ENG-SF21010-R1-CD-Redlines.pdf Markup Summary

DATE: MARCH 23, 2021
PROJECT NO. 100.062
SHEET NUMBER C6.4
TOTAL SHEETS: 42

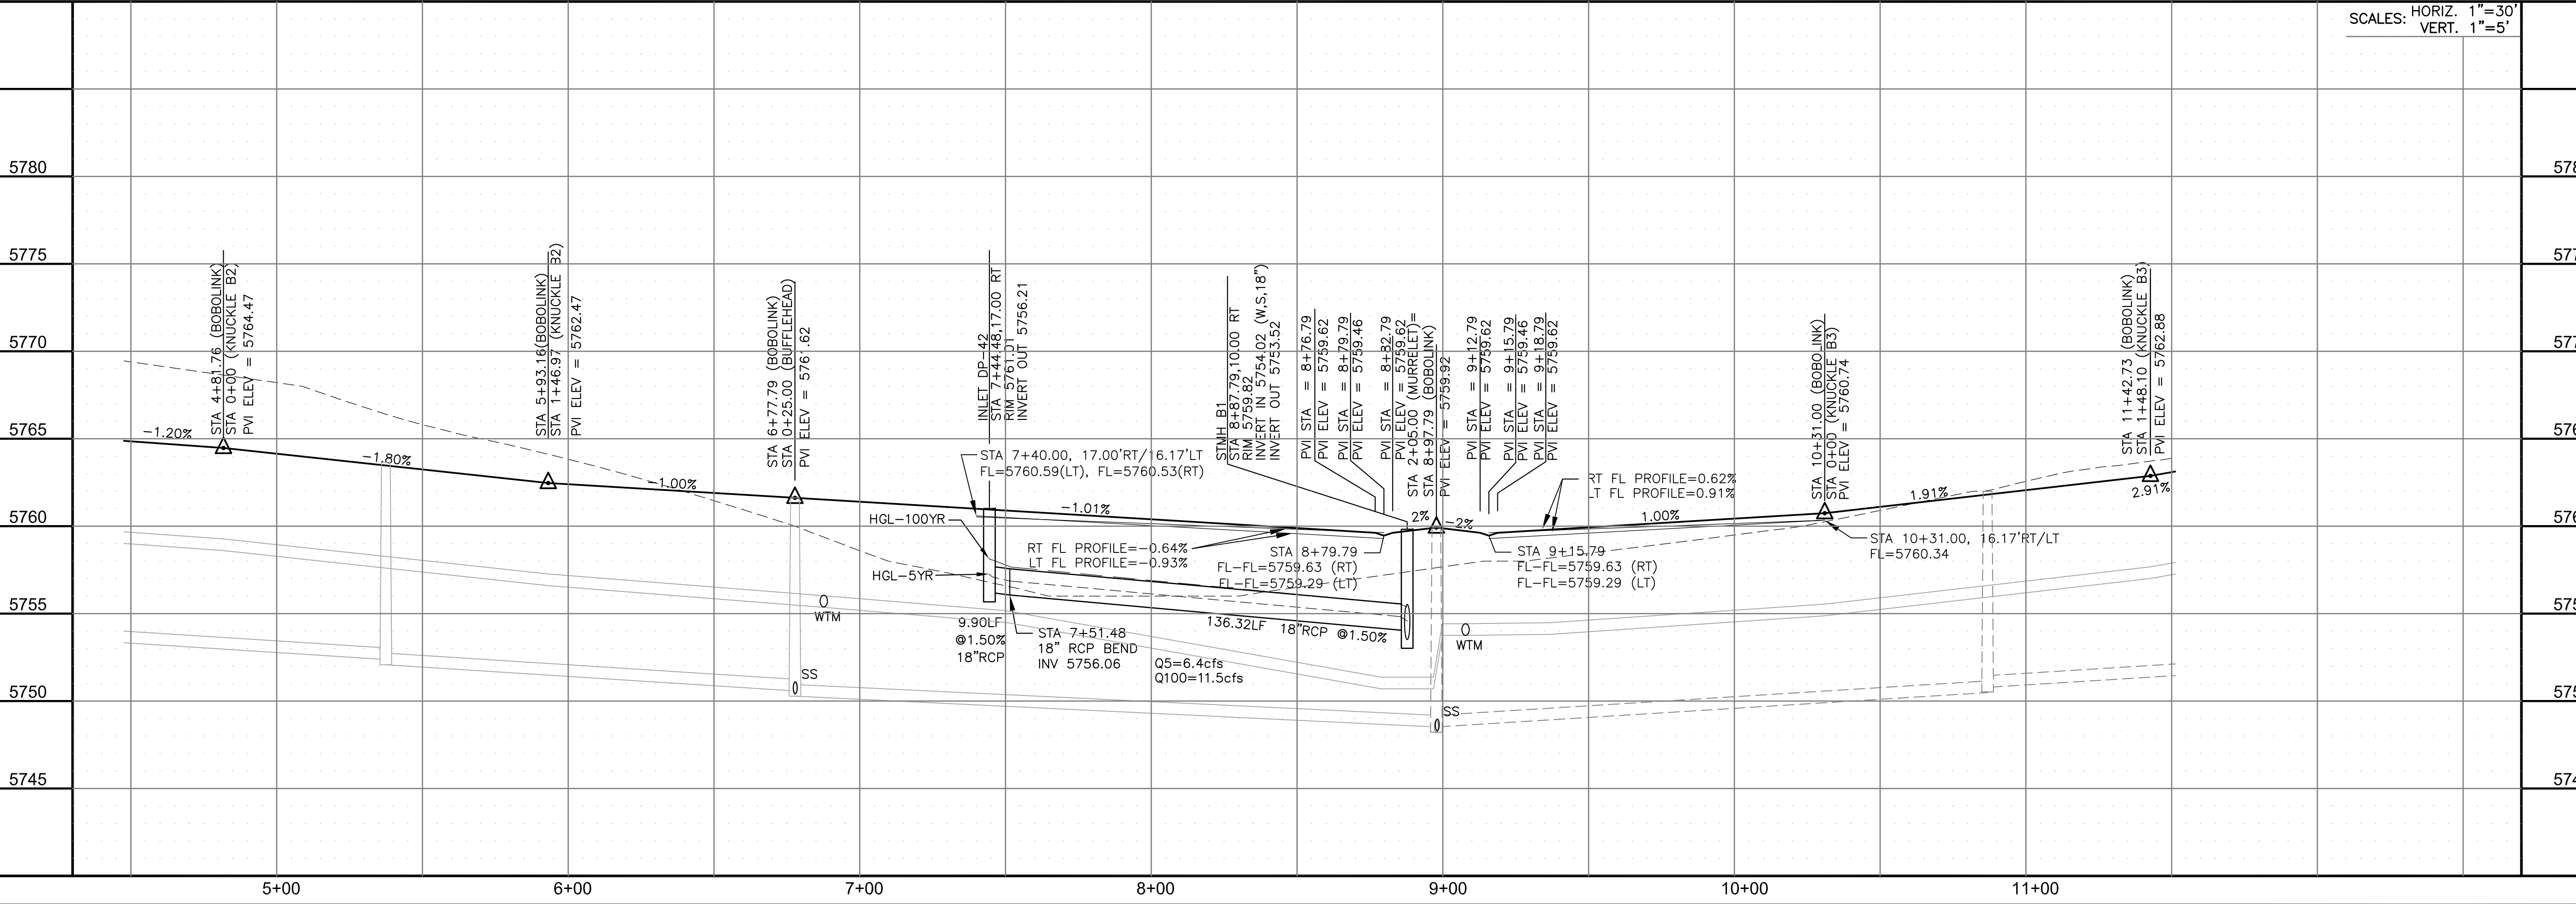
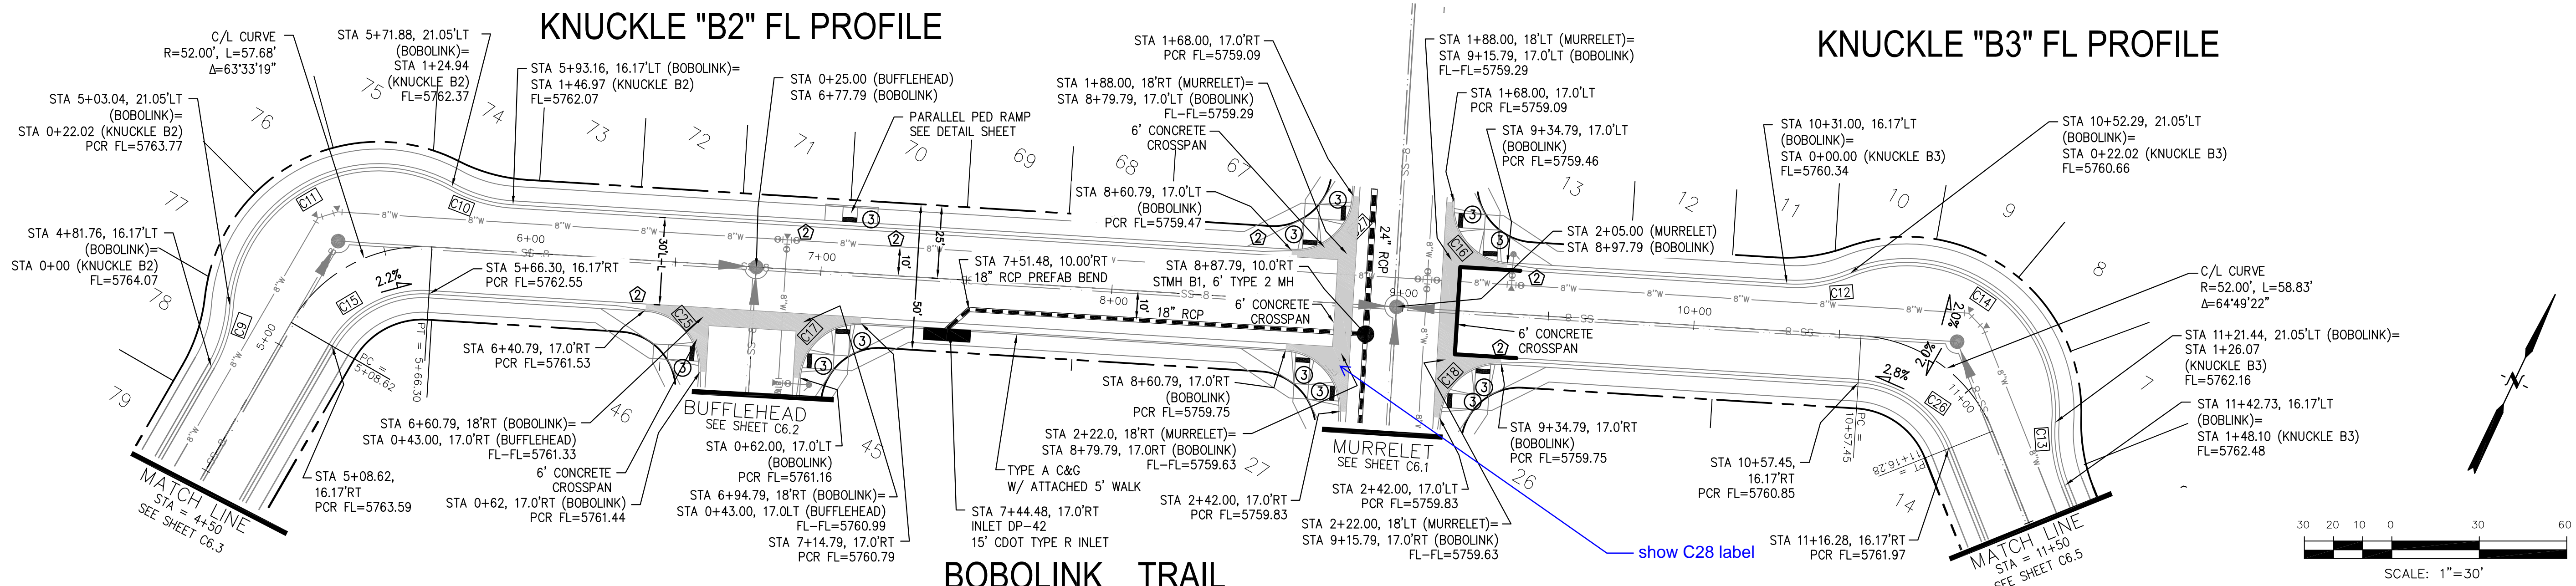
Should this be on a different sheet?

Curve table?

Curve table?
